**RE: Legacy Apartments - Oakland Roadway
Supplemental Drainage Analysis
Engineer's Stamp Date: 5/11/18
Hydrology File: C18D064B**

Based upon the information provided in your submittal received 05/11/2018, the Supplemental Drainage Analysis **is not** approved for Work Order. The following comments need to be addressed for approval of the above referenced project:

**RE: Oakland Roadway Inlet Analysis
Legacy Apartments**

GRADING AND DRAINAGE PLAN

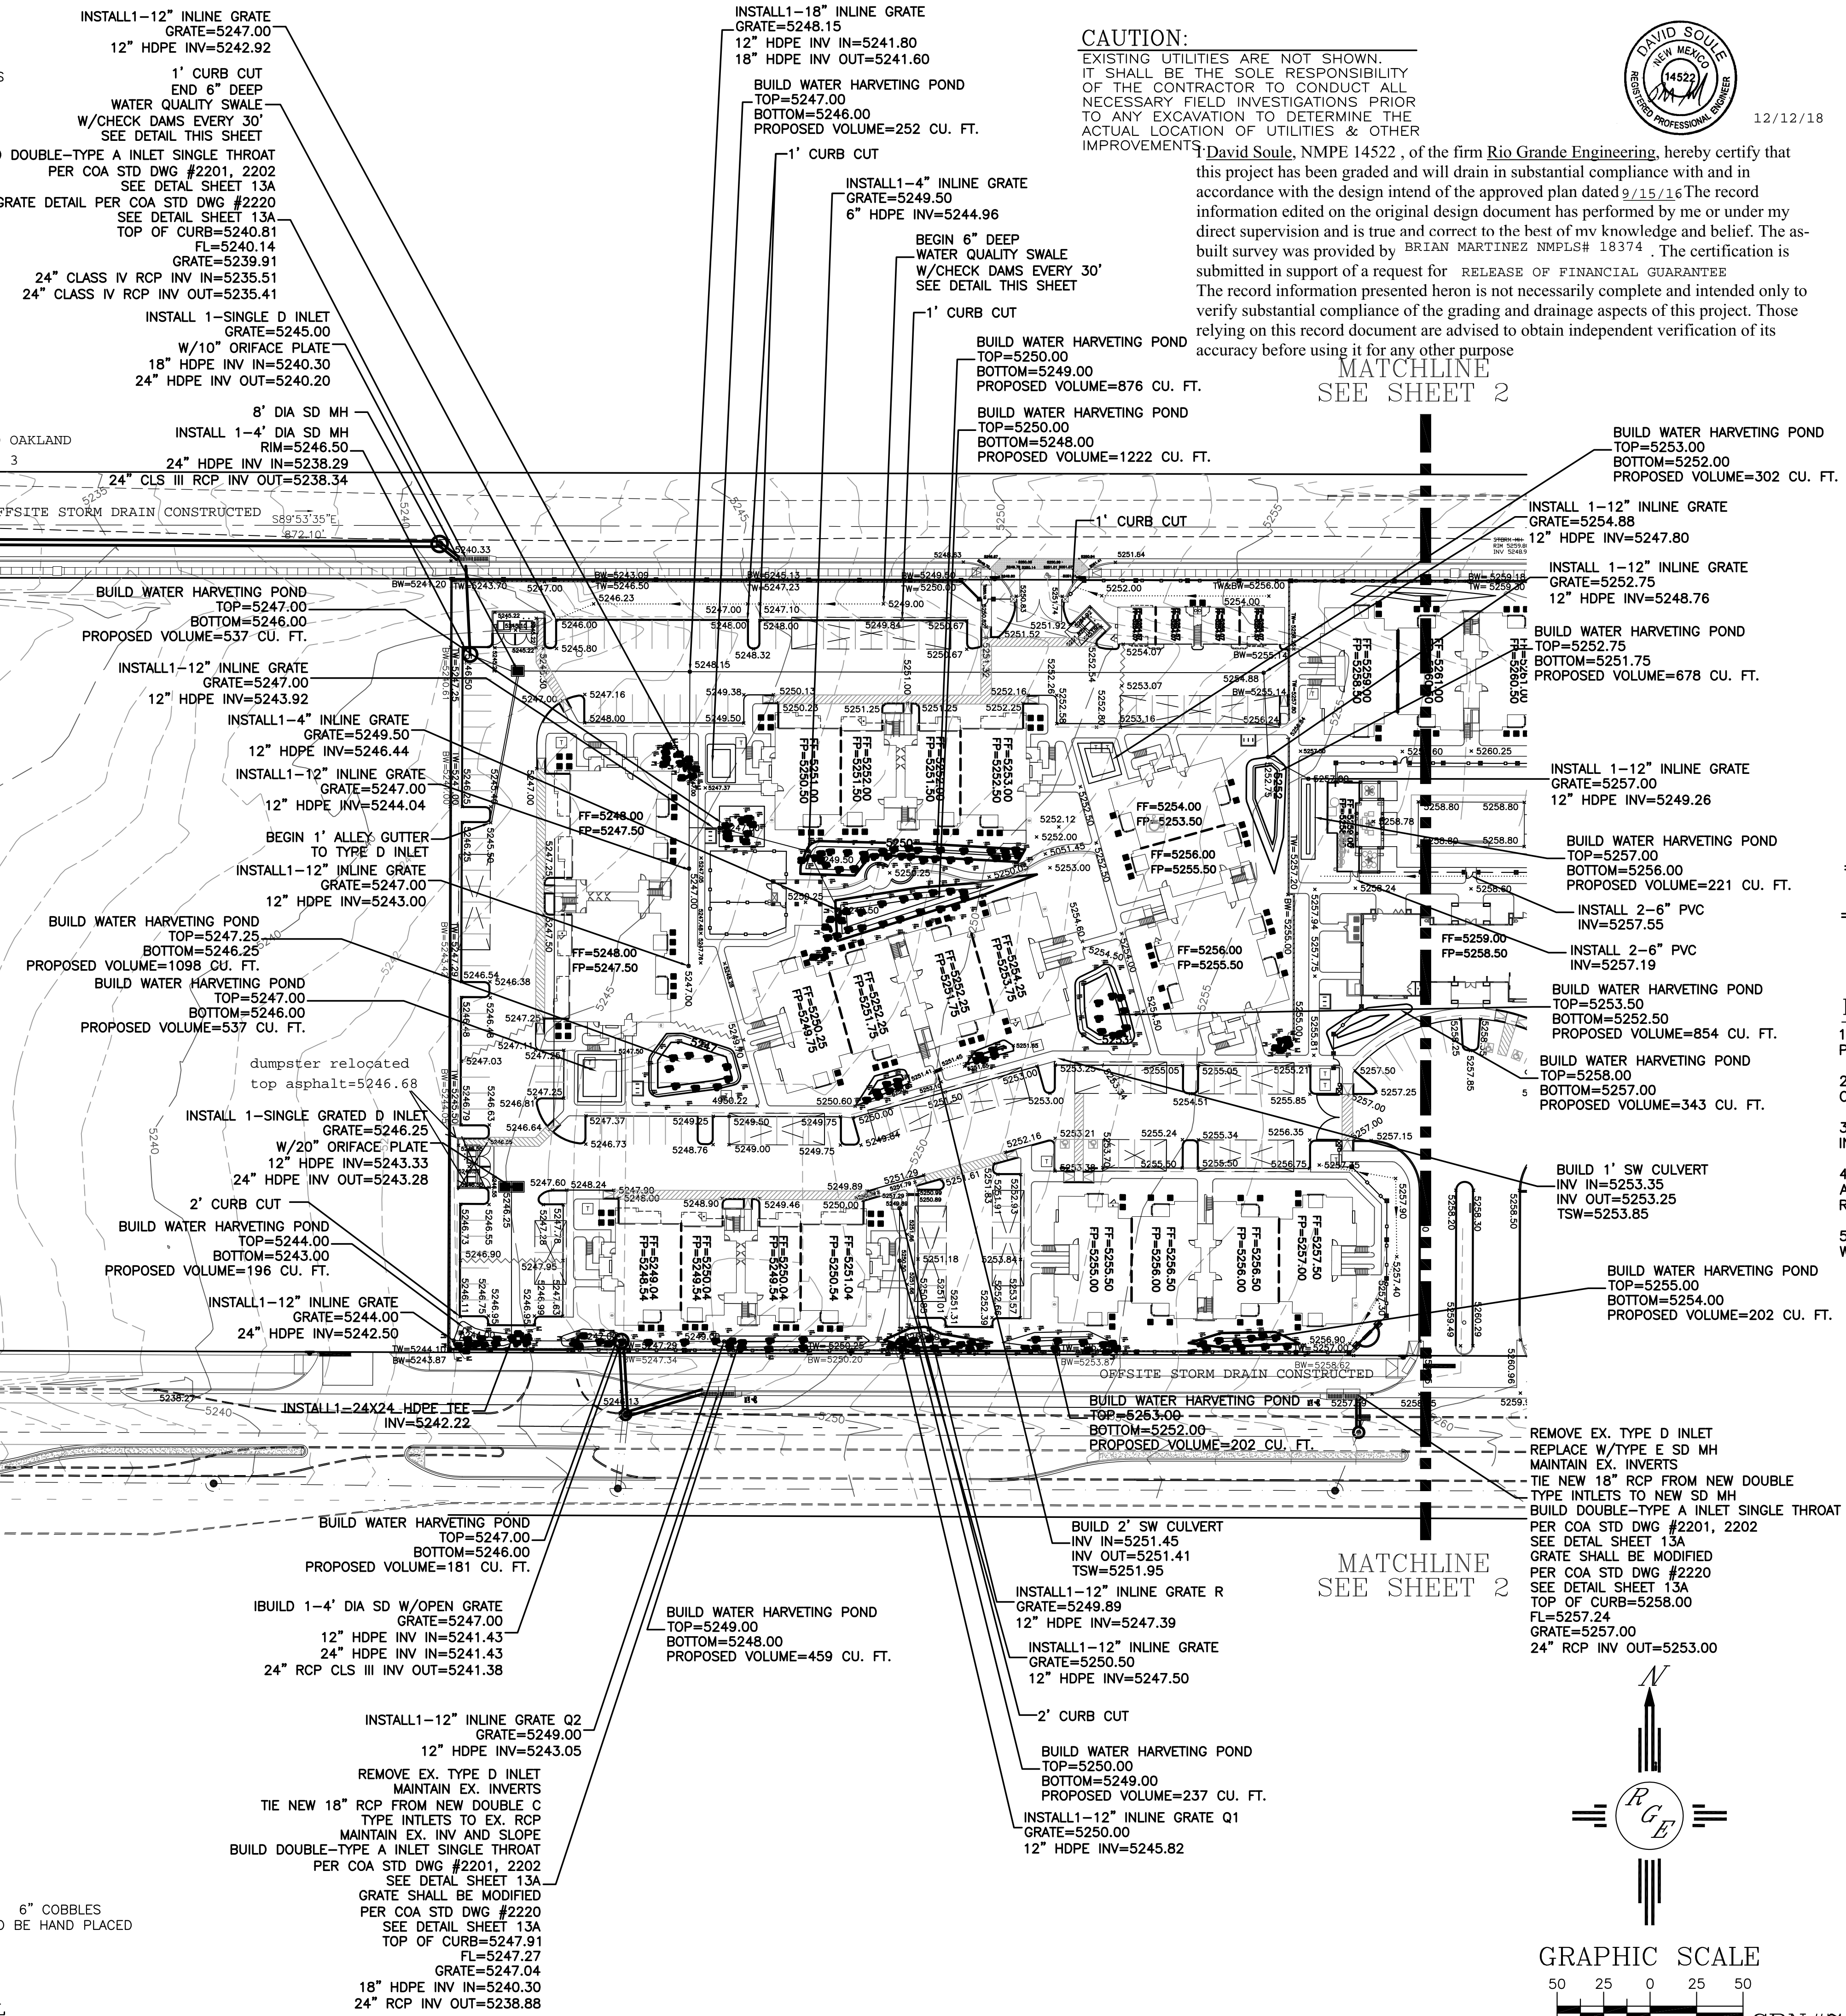
1. Please provide drainage watersheds outlines in our map. Also please add the storm drain and show the flow direction. (Please just show a little of the pipes that leave the analysis area.

2. AP1 Is a double "C" inlet and you have calculated the grate would capture 14 CFS however you used the nomograph for a single inlet "A", "C", and "D". Please use the nomograph for a double inlet. The amount captured should be a lot less than 14 cfs. AP3 is also a double "C" inlet. However by the time all the surface drainage reaches AP3, it is captured by this inlet.

3. It appears that the inlet that is to be proposed is AP5. This also looks like it is right on the existing pipe from the area inlet to the manhole at the corner of Oakland and San Pedro. However, the road section here does not have a crown section so the runoff flows will not be captured by the inlet and will spill into San Pedro where there is no method to capture the runoff. This proposed inlet looks like it should be placed to the east where the road still has a crown section and then connected to the existing storm pipe.
